Sustainable Traffic Solutions

September 13, 2024

RE: Responses to Comments on the Traffic Impact Study for the Haven School

El Paso County provided comments on the traffic impact study for this project that was dated June 25, 2024. Sustainable Traffic Solutions has responded to the comments as noted below.

Haven School Traffic Impact Study
 CONCEPTUAL IMPROVEMENT SKETCH FOR BURGESS ROAD AT MILAM ROAD

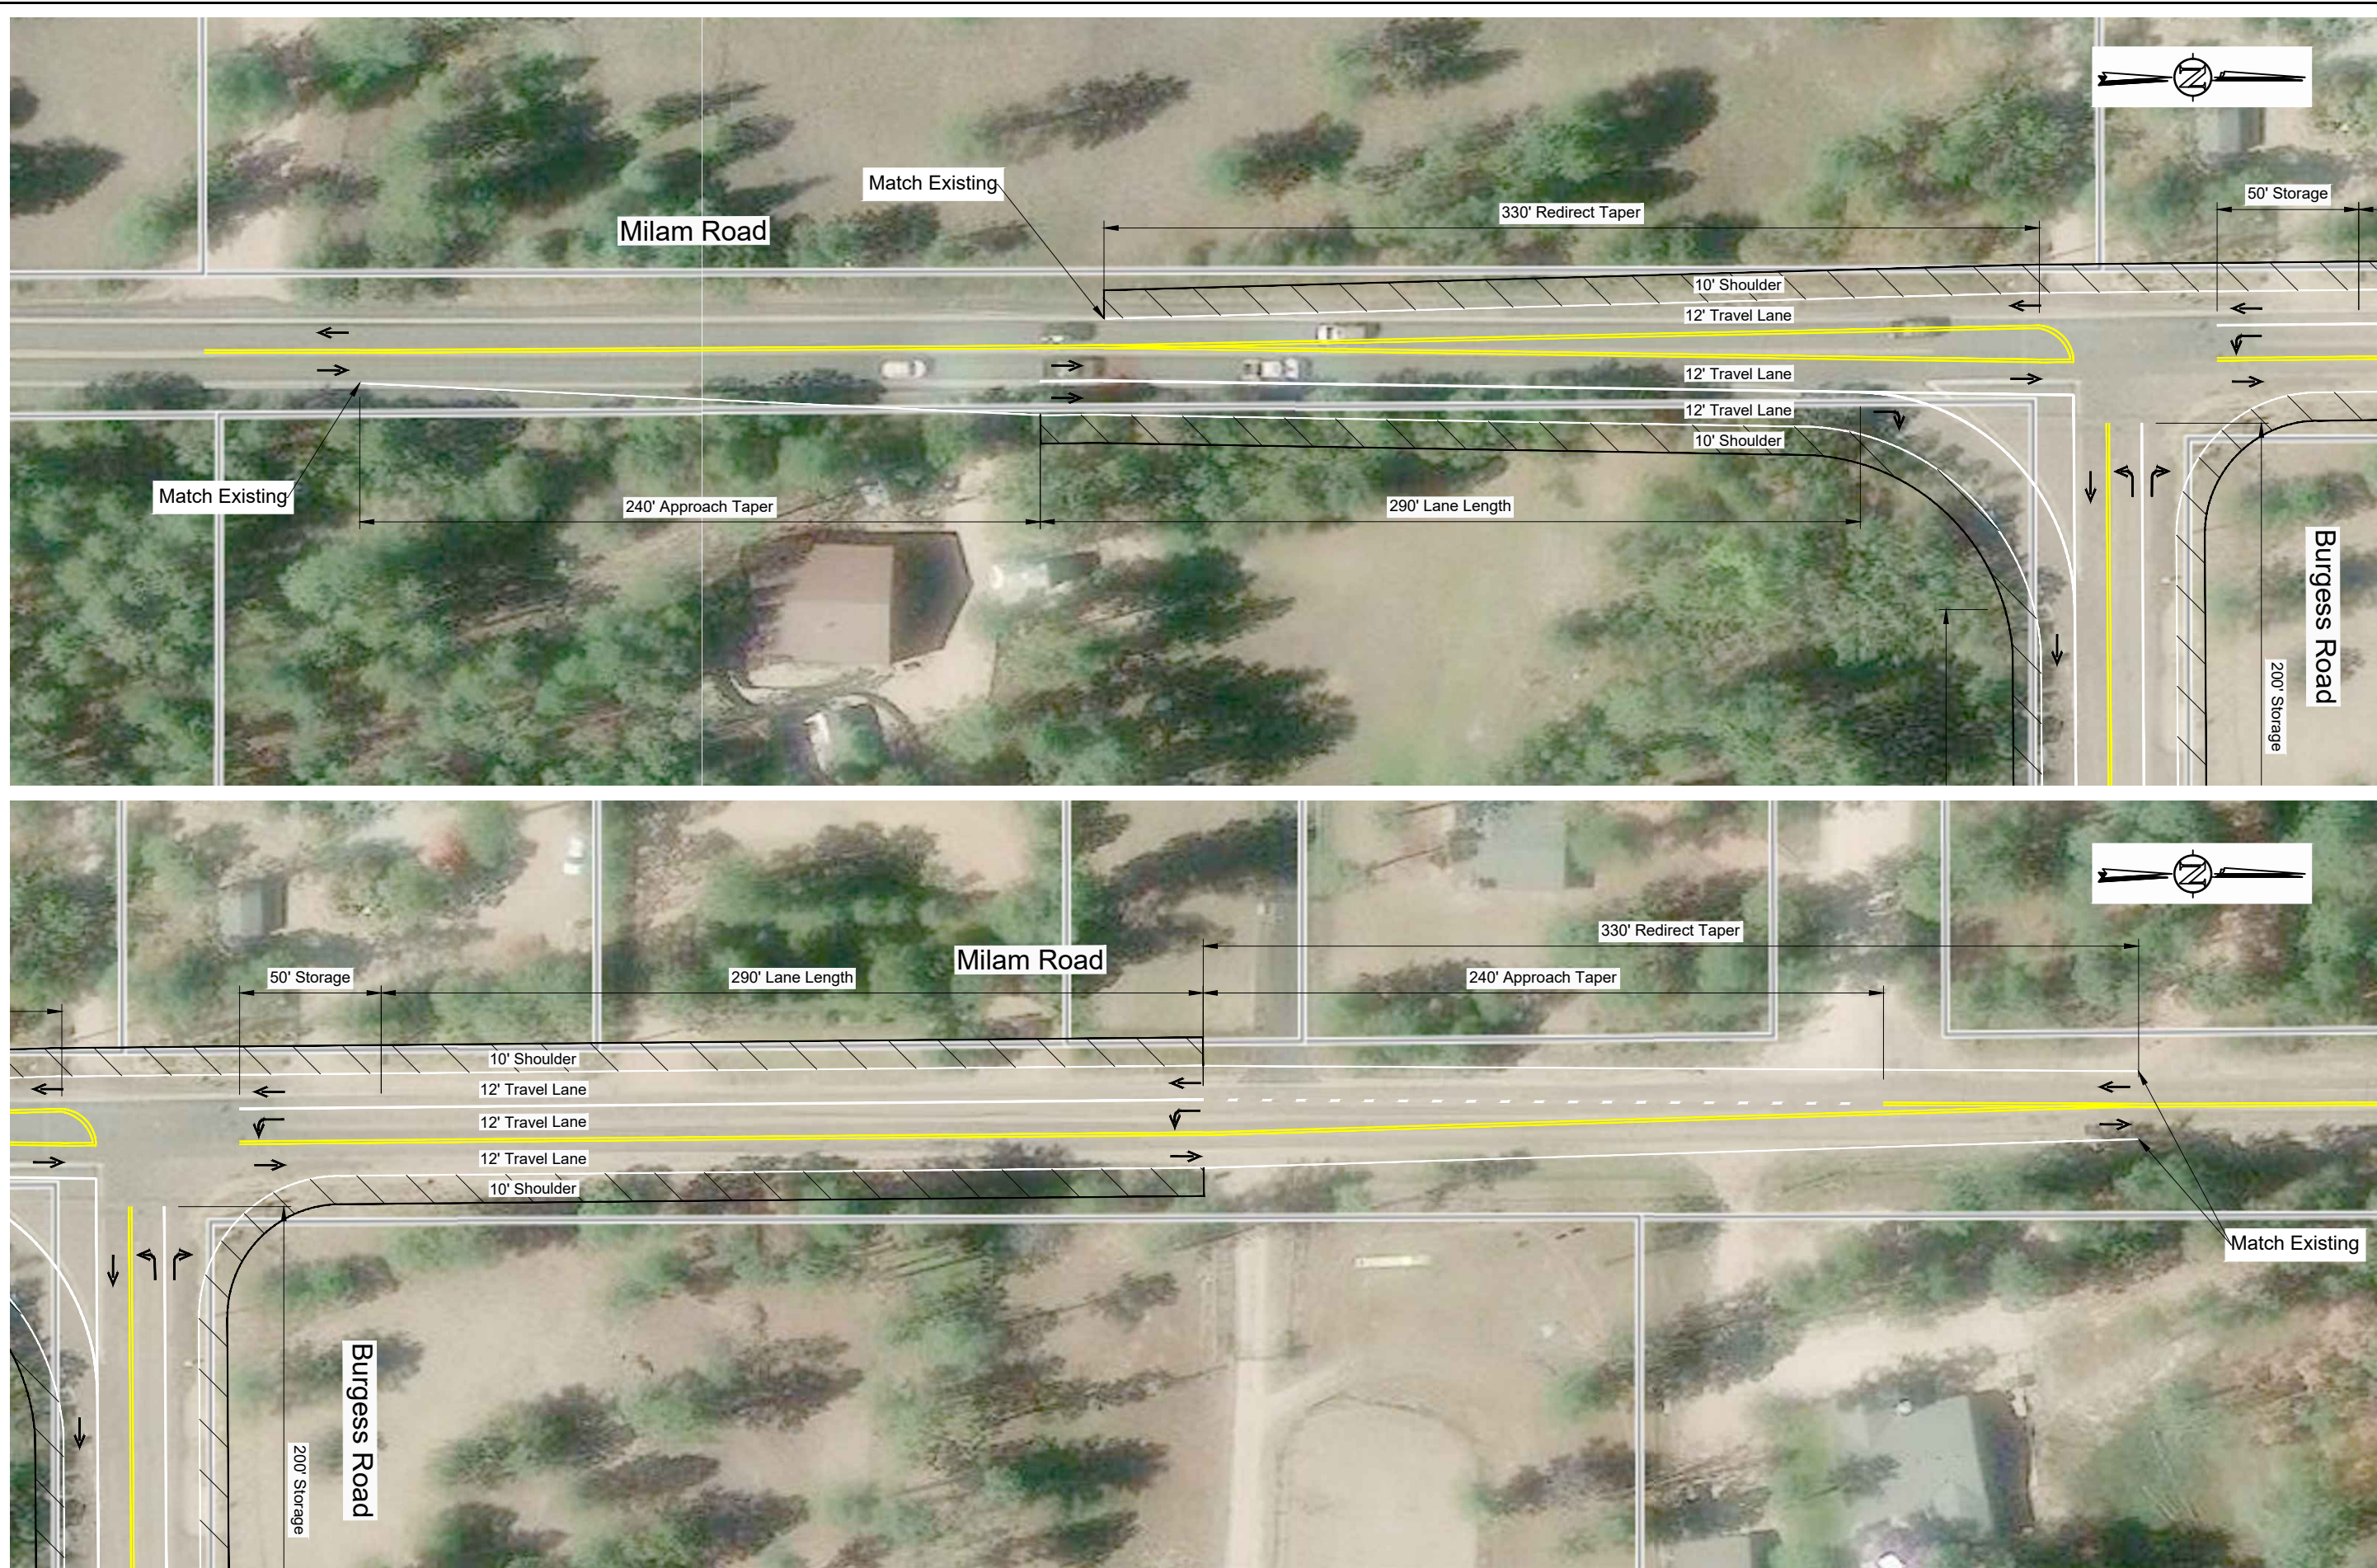
Comment 1 Add and compare LOS analysis if lane improvements are not added at Milam and Burgess. (Refers to the Year 2026 traffic conditions.)

Comment 2 Discuss if the current peak hour has tripped the needed lane improvements at Milam and Burgess without the school added. Discuss that the Milham and Burgess intersection can operate safely with the school open and the off-site improvements not completed (not including access improvements on Burgess). (Refers to the auxiliary lane review.)

Response Refer to Section 5.0.

Response Refer to Section 9.0 and Table 4.

Figure 22 – Intersection Sight Distance at the Site Access on Burgess Road

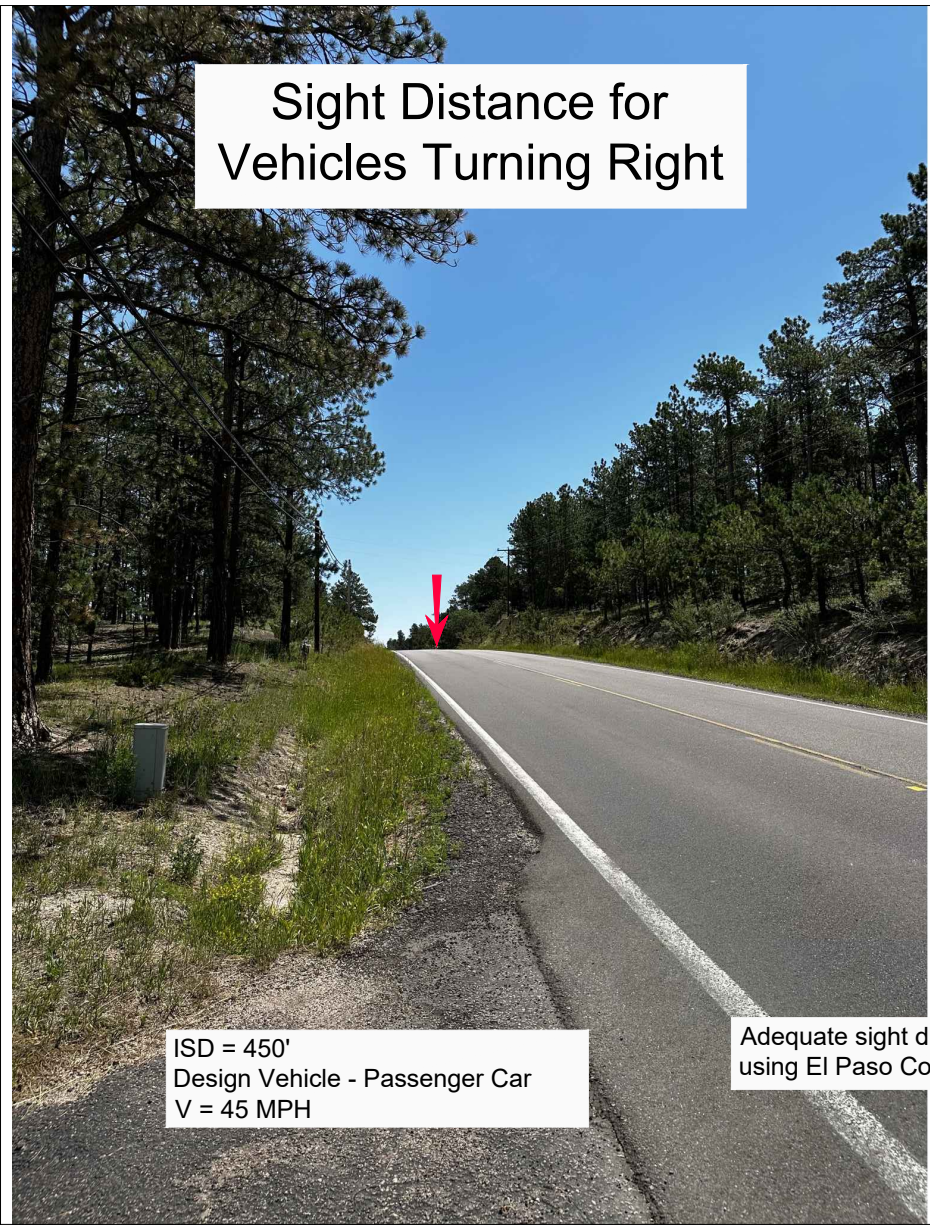
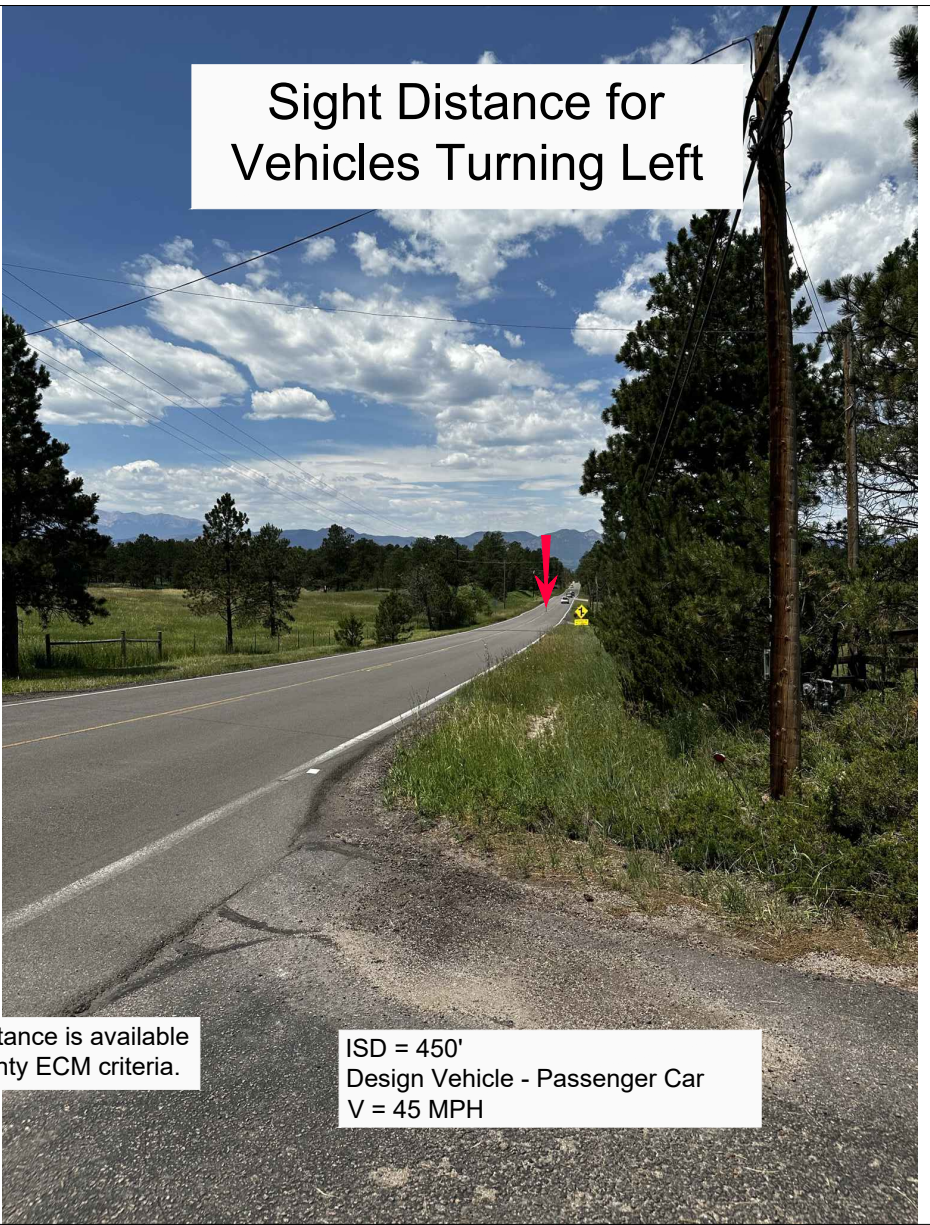
Comment 4 note this will be a condition of approval to restrict bus service due to line of sight not able to be met (Refers to Section 10.0.)

Response The school understands this.
